DRB Application No.: 09DRB-70292

Project # 1007771

Project Name: COMPANY'S FIRST ADDITION TOGETHER WITH PORTION OF VACATED ALLEY

**RE: Lots 8 & 9, Block 1, Realty Sales Co.'s 1<sup>st</sup> Addition**

PLAT OF
 LOT 8-A
 REALTY SALES COMPANY'S FIRST ADDITION
 PROJECTED SECTION 30, T. 10 N., R. 3 E., N.M.P.M.
 ALBUQUERQUE GRANT
 CITY OF ALBUQUERQUE
 BERNALILLO COUNTY, NEW MEXICO
 JULY 2009
 SHEET 2 OF 2

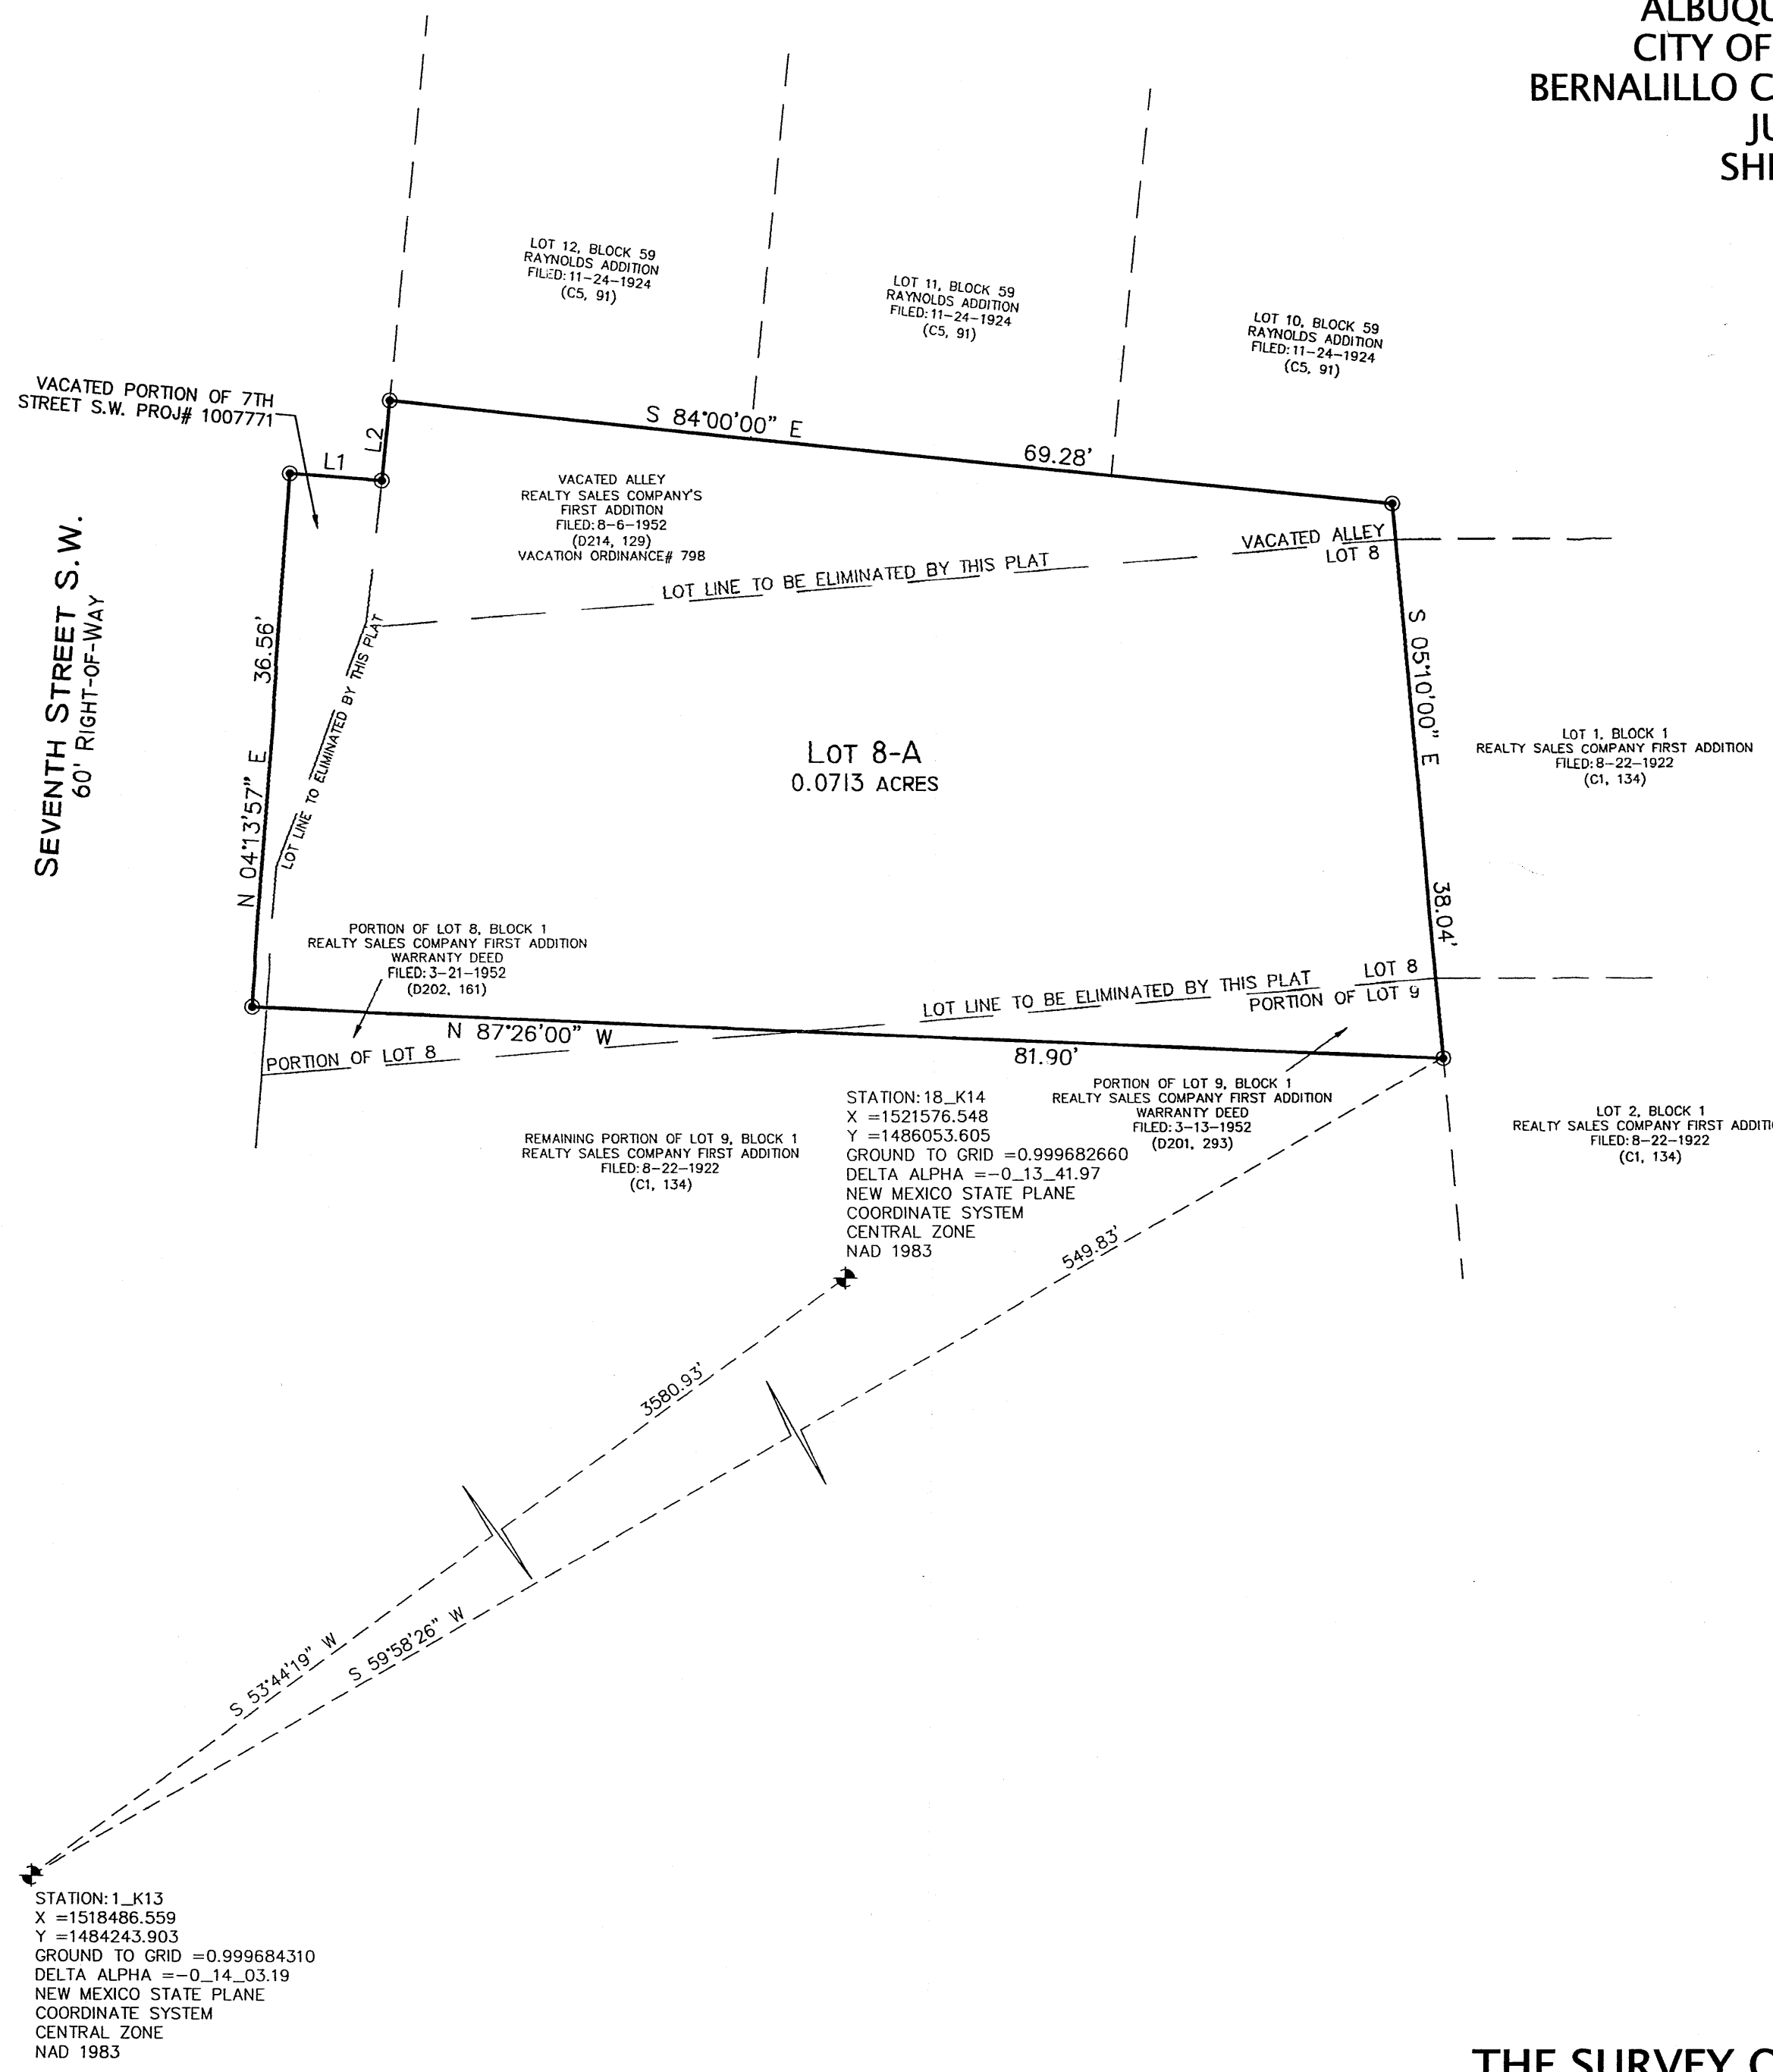
It does not appear appropriate to have a 'notch' in front of this lot; uniform property lines are desirable in order to provide harmonious development and orderly physical patterns per the PURPOSE AND INTENT of the Subdivision Ordinance [§ 14-14-1-3].
